**United Utilities Water Limited  
Developer Services & Metering**  
2<sup>nd</sup> Floor, Grasmere House  
Lingley Mere Business Park  
Lingley Green Avenue  
Warrington  
WA5 3LP

**Your ref:** 3/2018/0913  
**Our ref:** DC/18/4494  
**Date:** 29-OCT-18

**Location : Land off Clitheroe Road adj Shaw House Farm BB7 9AD**

**Proposal : Installation of a backup electrical generation hub together with security fencing, access, substation**

## SHAWHOUSE, WHALLEY - SITE LAYOUT

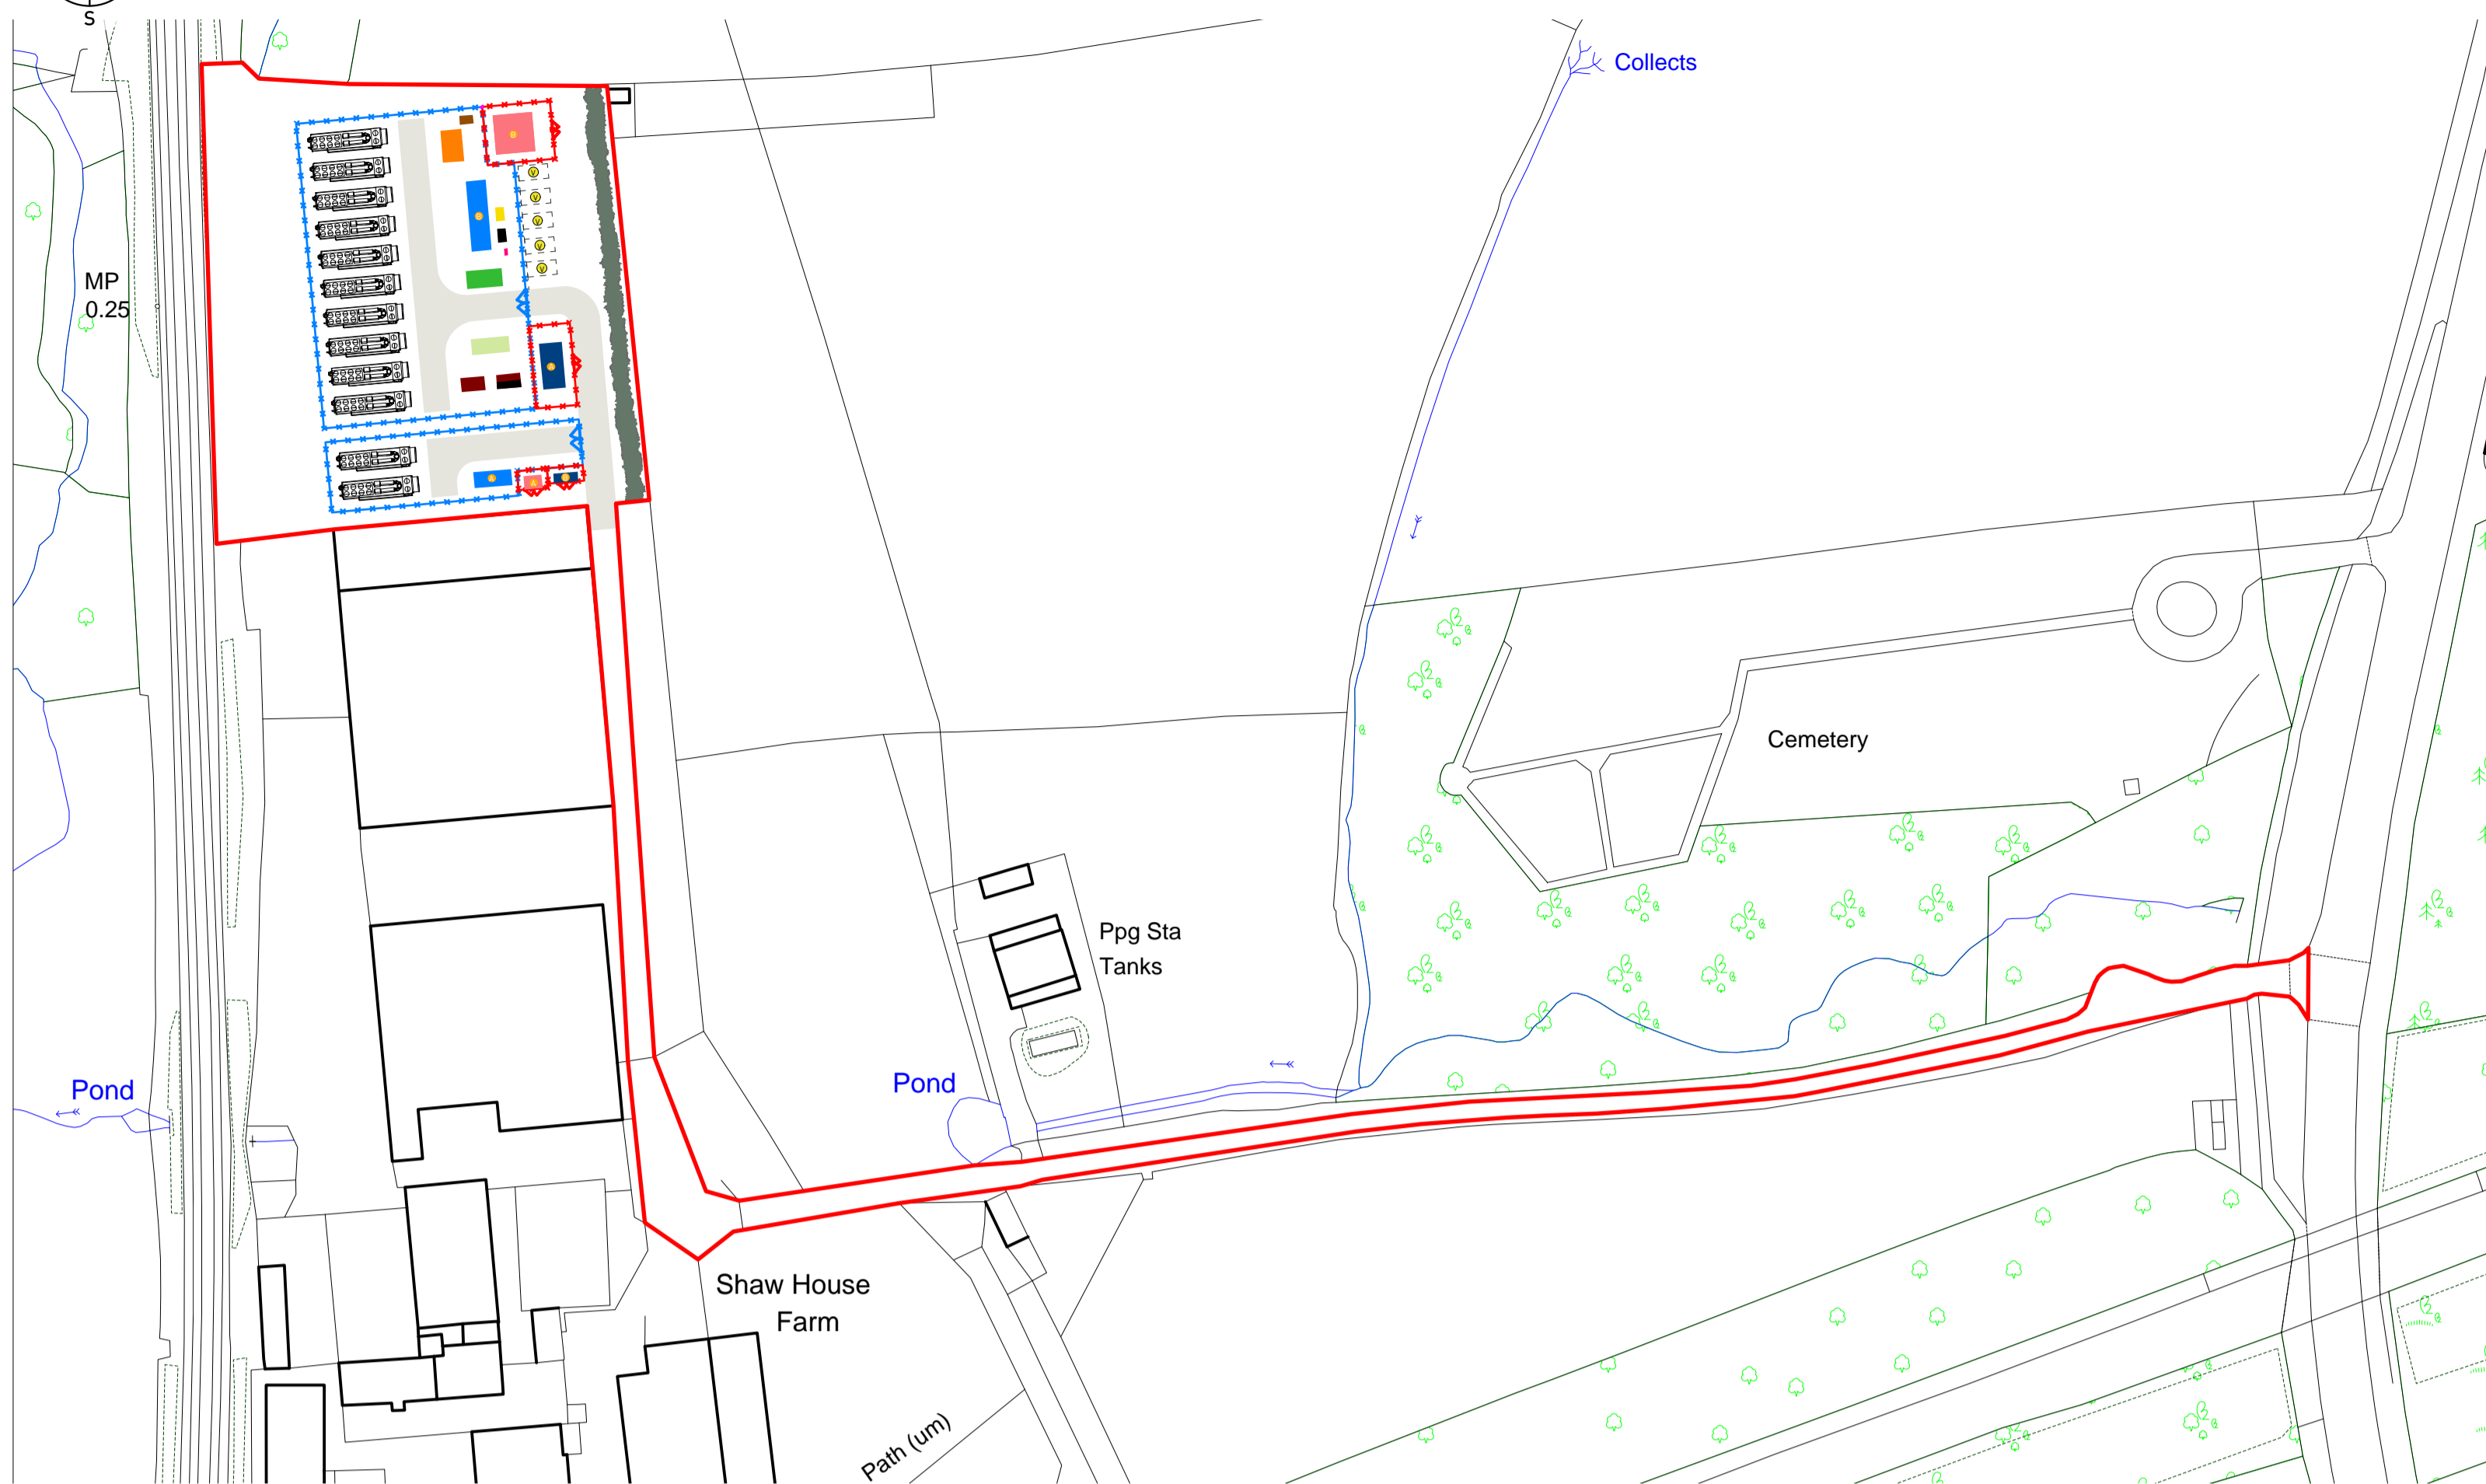
A water main crosses the site. As we need unrestricted access for operating and maintaining it, we will not permit development over or in close proximity to the main. We require an access strip as detailed in our Standard Conditions for Works Adjacent to Pipelines, a copy of which is enclosed.

The applicant must comply with our 'Standard Conditions' document. This should be taken into account in the final site layout, or a diversion may be necessary. Unless there is specific provision within the title of the property or an associated easement, any necessary disconnection or diversion required as a result of any development will be at the applicant's expense. If considering a water

KEY: SITE LOCATION PLAN

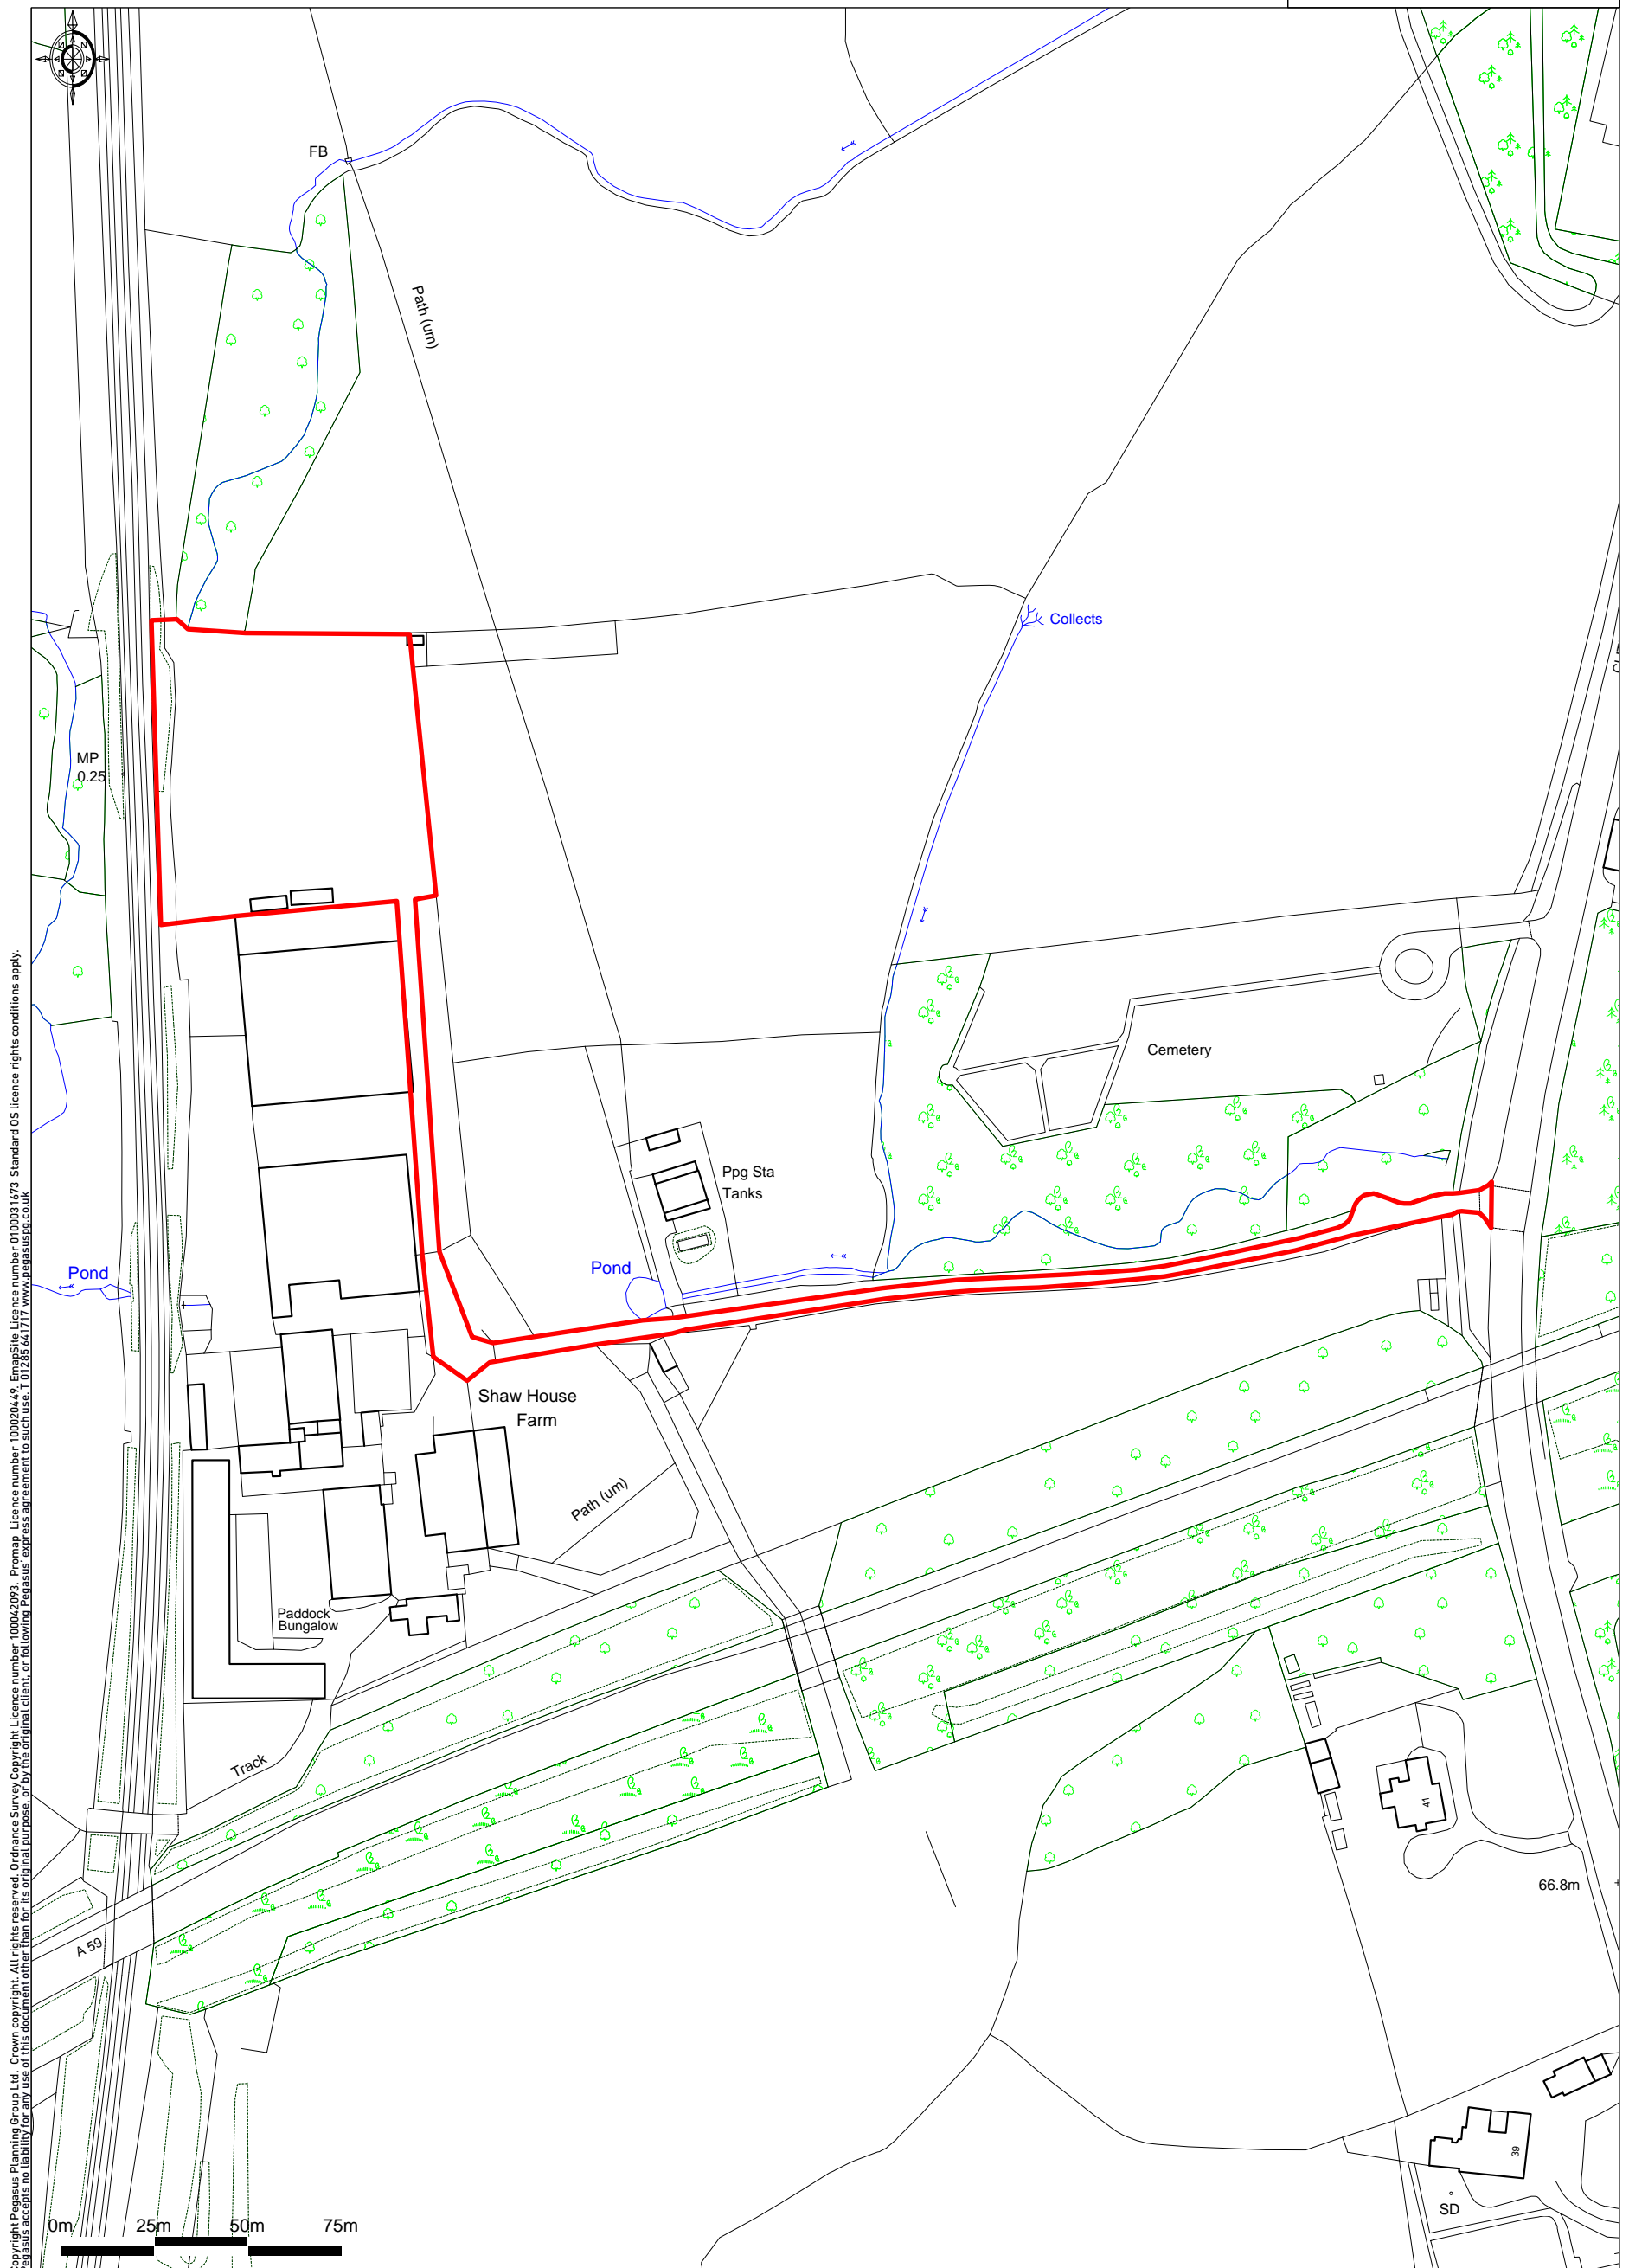
Under title number LAN56372 United Utilities land has been included within the development, please amend your application to remove land belonging to United Utilities. Please also take into consideration United Utilities has a right of way to Whalley Valve House, reference 40/00198.

Under conveyance dated 14/02/1933 ref 40/00264 United Utilities land has been included within the development, please amend your application to remove land belonging to United Utilities.
